**Re: Markana Flats at 7050 Constitution Ave NE  
Erosion and Sediment Control Plan  
Engineer's Stamp Date 1/9/2023 (L09E042)**

Based upon the information provided in your submittal received 2/7/2023, the above-referenced ESC Plan is conditionally approved to be in the SWPPP for the purposes of Grading Permit., however it is not approved for Building Permit until the following additional information is provided.

TEMPORARY EROSION AND SEDIMENT CONTROL PLAN

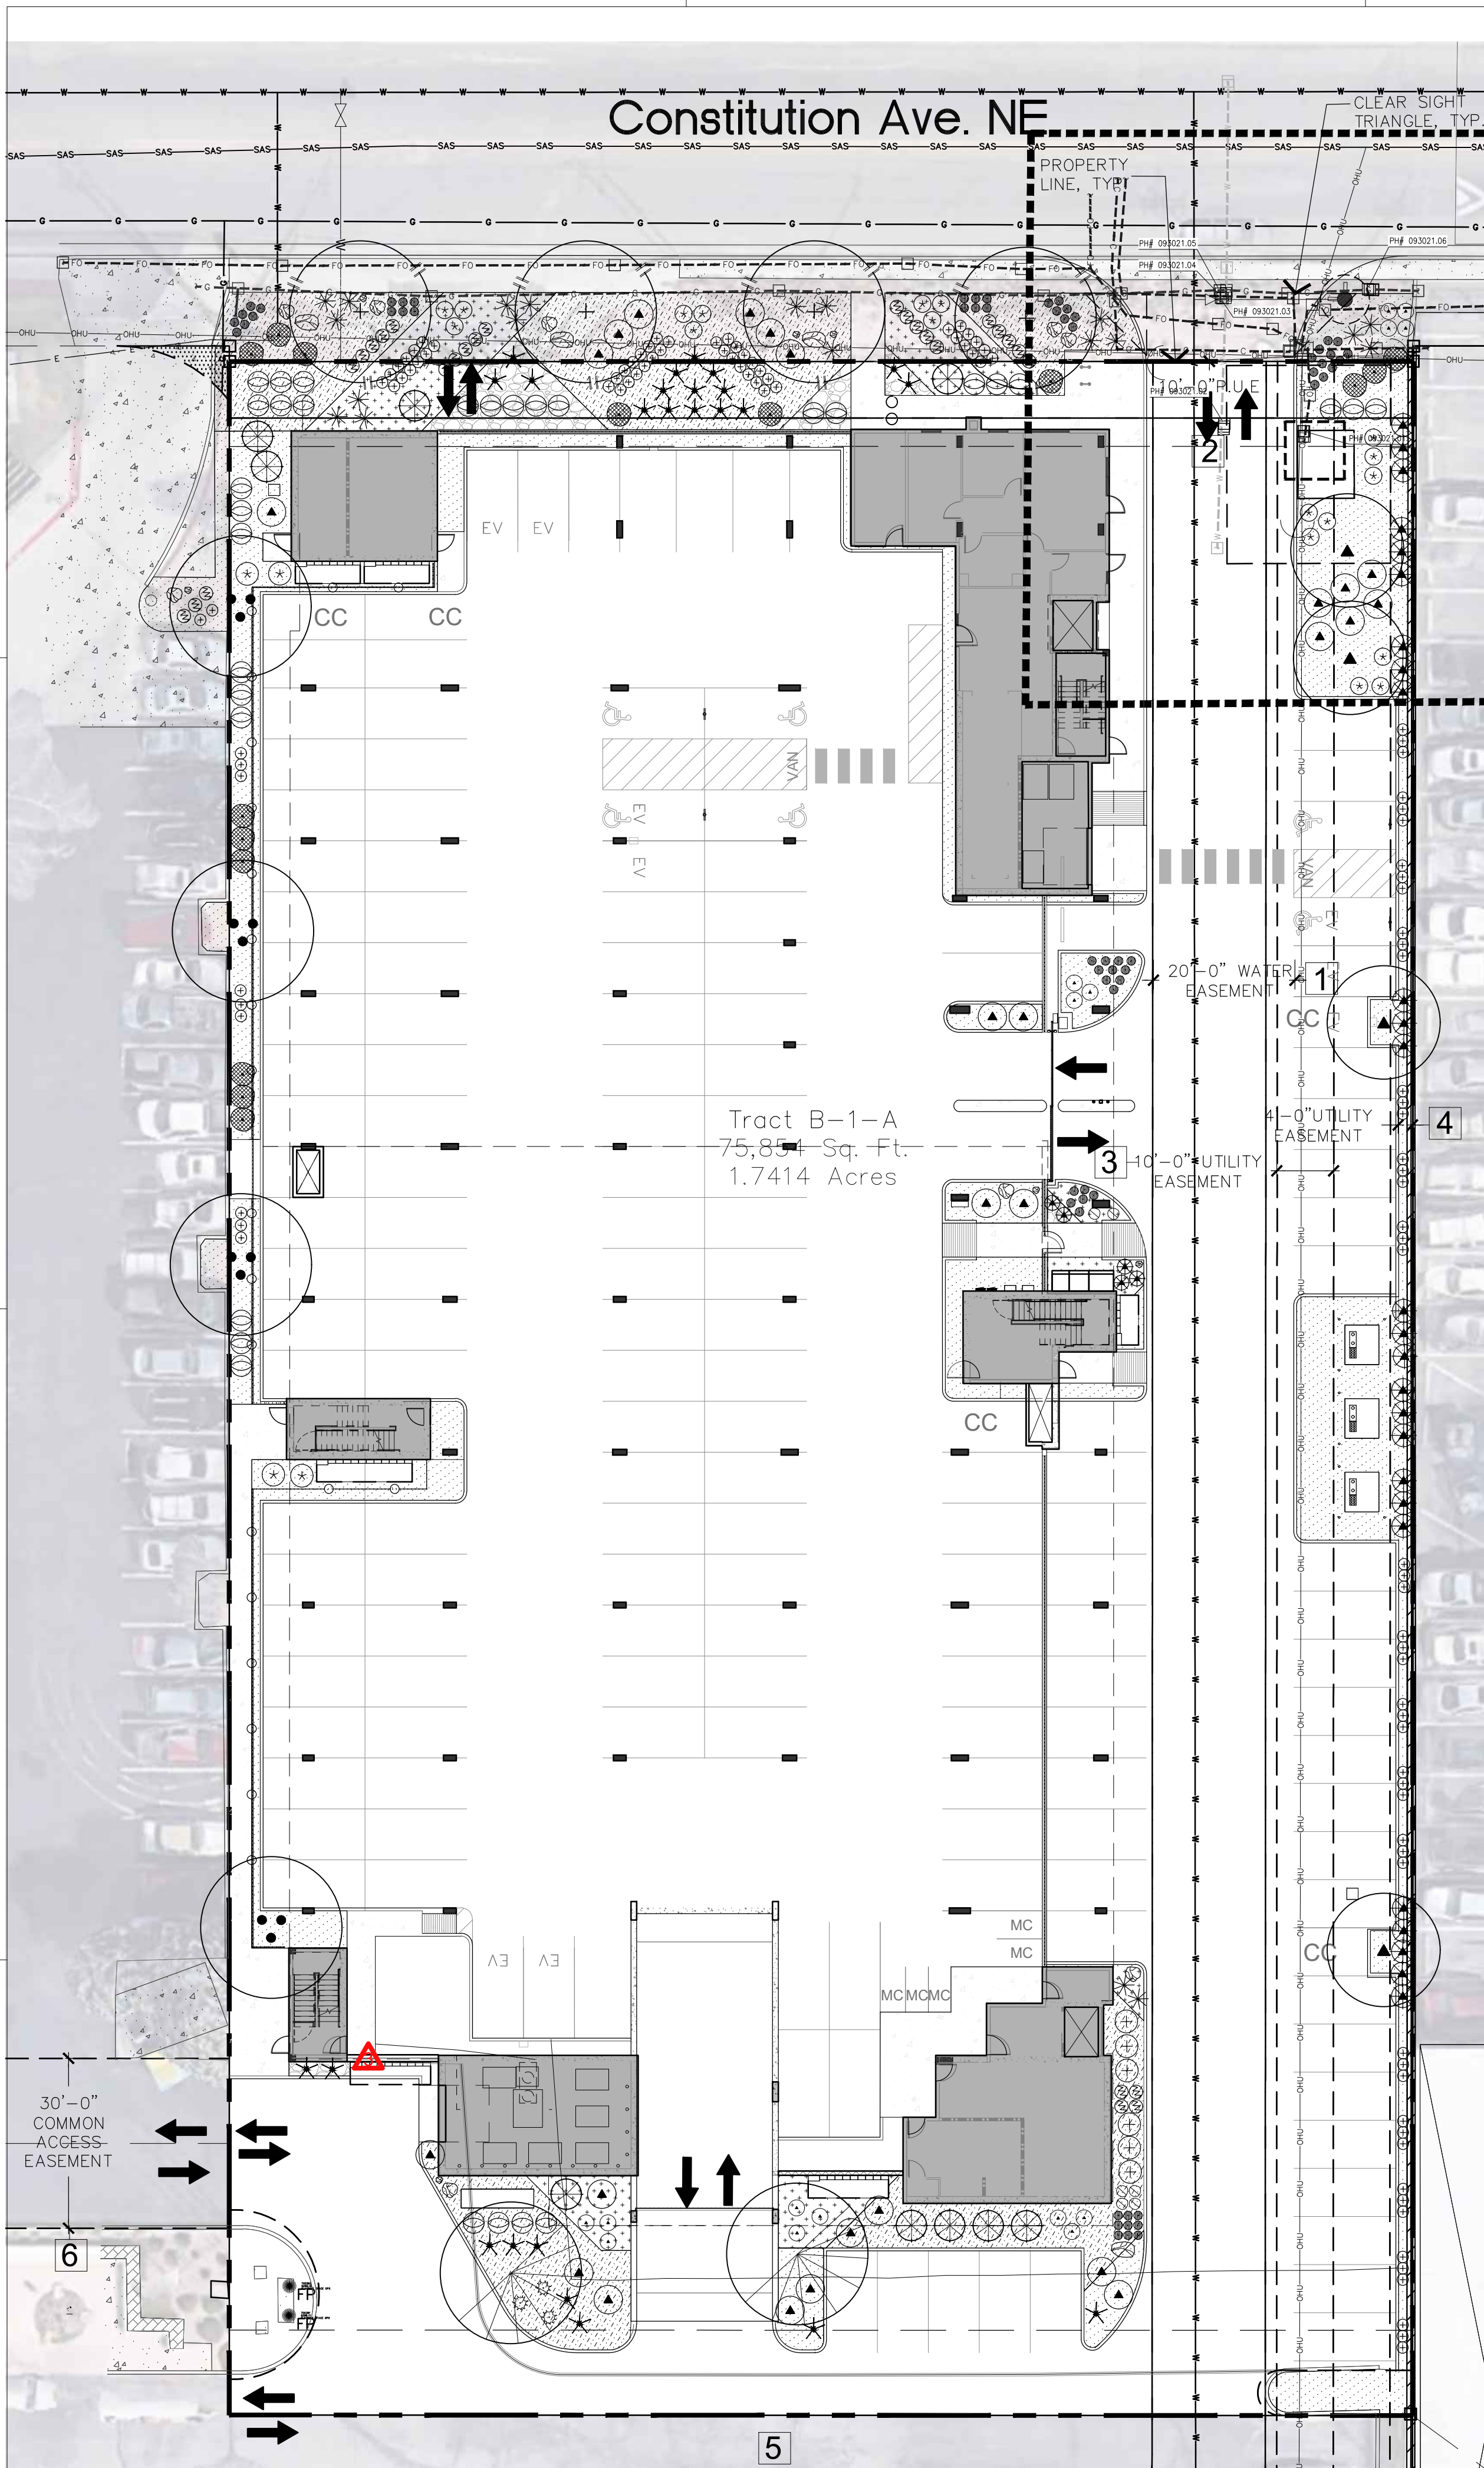
1. Corrections are still on the first sheet of the ESC Plan. The vicinity map on Sheet 1 of 6 shows a location on Airport Blvd. NW.
2. Silt Fence is required around the exposed perimeter (North, West, & South). It isn't needed on the east side where the existing block wall will be a sufficient perimeter control.
3. Update the engineer's stamp date each time the plan is changed.
